Application No: AW/3/21/HH
Site Address: 4 Shorecroft Aldwick PO21 4AS
Description of works: Single storey rear extension and loft conversion with enlarged rear dormer window and two modest front facing dormer windows. Alterations to fenestration, Canopy to side elevation, Planter and replacement handrail to roof terrace.

Thank you for your internet representation made on 26th January 2021 which has been recorded as an objection with the comments as follows:

Drawing No. Date:
C.1062H - 04 22-12-20

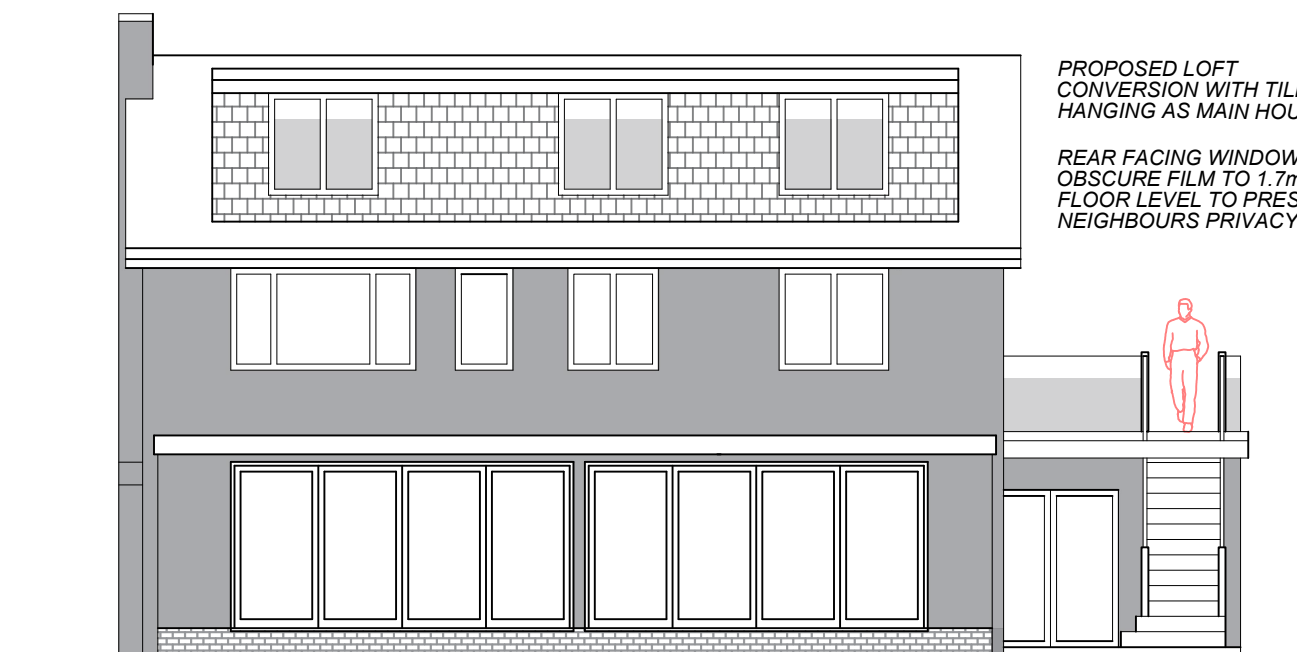
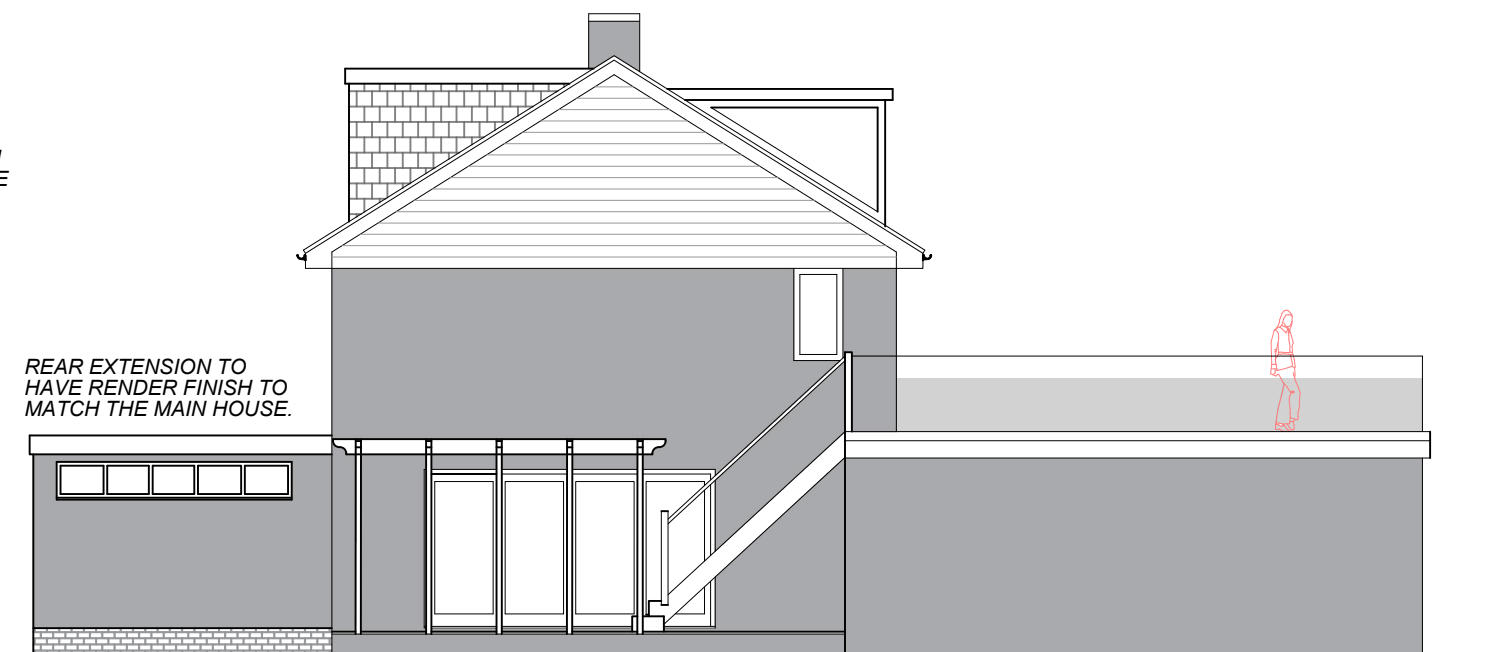
I have recently been made aware of a planning application which involves a number of external changes to the above property, most notably the installation of dormer windows that will project from the existing roof line.

Firstly, the impact of these windows on the neighbours and surrounding properties on the estate, including as far as Wallfield and Hornbeam, will be severe. Upon installation of the windows, the property will have a direct line of vision to the gardens and main living rooms of the properties at the rear, which will significantly reduce the utility and amenity of neighbours' outdoor spaces. The conversion will also create a large and overbearing side elevation which will be both unattractive to surrounding properties, including my own on Wallfield and inconsistent with the image of the estate.

Secondly, whilst other properties have been granted permission in the past for loft conversions, this has only been for Chalet Bungalows, which do not impact the privacy of surrounding properties. By granting permission, the Council will be setting a precedent from which other properties will be able to apply for loft conversions, effectively creating three-storey buildings, which are not in keeping with the appearance and character of the estate.
